Application No: FG/17/22/HH
Site Address: 44A Ocean Drive Ferring BN12 5QP
Description of works: Erection of single storey rear extension following the demolition of existing conservatory.

Thank you for your internet representation made on 11th February 2022 which has been recorded as an objection with the comments as follows:

SITE PLAN 1:500 @ A1

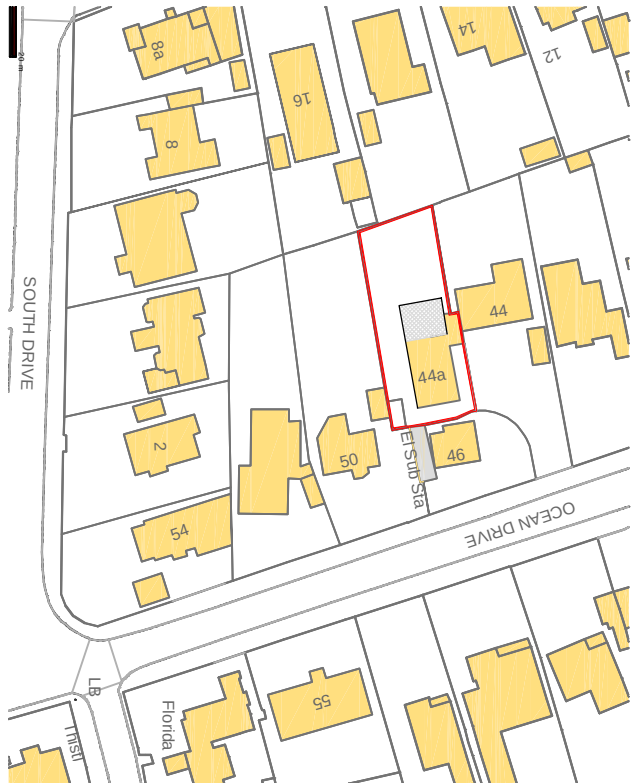
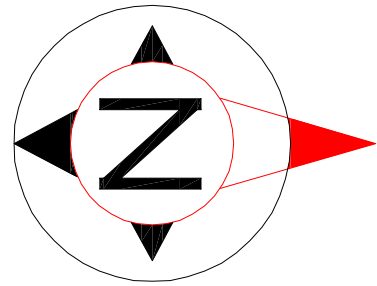
The site and location plan submitted in respect of this application are both incorrect. The applicant's curtilage is shown to include an outbuilding which belongs to 50 Ocean Drive.
